Mr David Gibson  
Team Leader  
Social Infrastructure Assessments  
Department of Planning and Environment  
GPO Box 39  
Sydney NSW 2001

**Regiment Mixed-Use Redevelopment Project at the University of Sydney  
Darlington Campus (SSD 7417) - Notice of Exhibition**

Thank you for your letter dated 6 March 2017 requesting Transport for NSW (TfNSW) comment on the above.

Figure 5.1: Short term bicycle parking

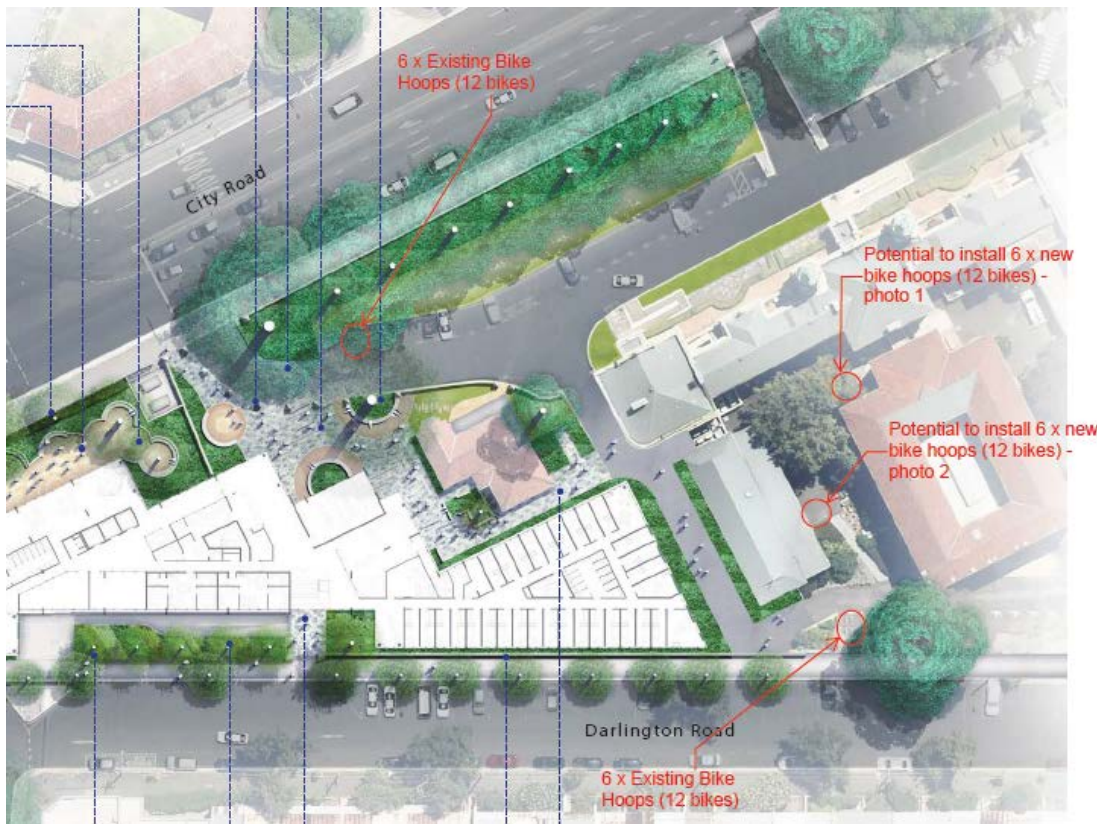
It is noted that Section 5.1 of the Traffic Impact Assessment states that a total of 223 bicycle parking spaces have been envisaged for the proposal

- Locate bicycle facilities in secure, convenient, accessible areas close to the main entries incorporating adequate lighting and passive surveillance and in accordance with Austroads guidelines;
- Develop wayfinding strategies and travel access guides to assist with increasing the mode share of walking and cycling; and
- The bicycle parking provision should be in accordance with Australian Standards Bicycle Parking Facilities AS2890.3.

Figure 5.3: Pedestrian Island Expansion

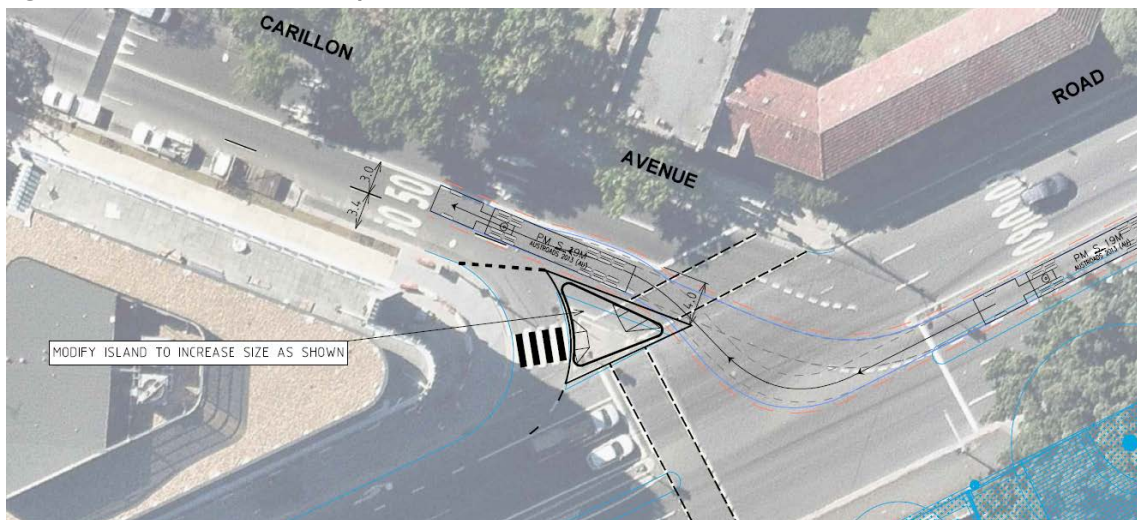
The proposal suggests that the pedestrian island located on City Road and Carillon Avenue should be increased.

TfNSW advises that City Road is classified State Road and the applicant needs to consult with Roads and Maritime Services for any changes to the pedestrian island.
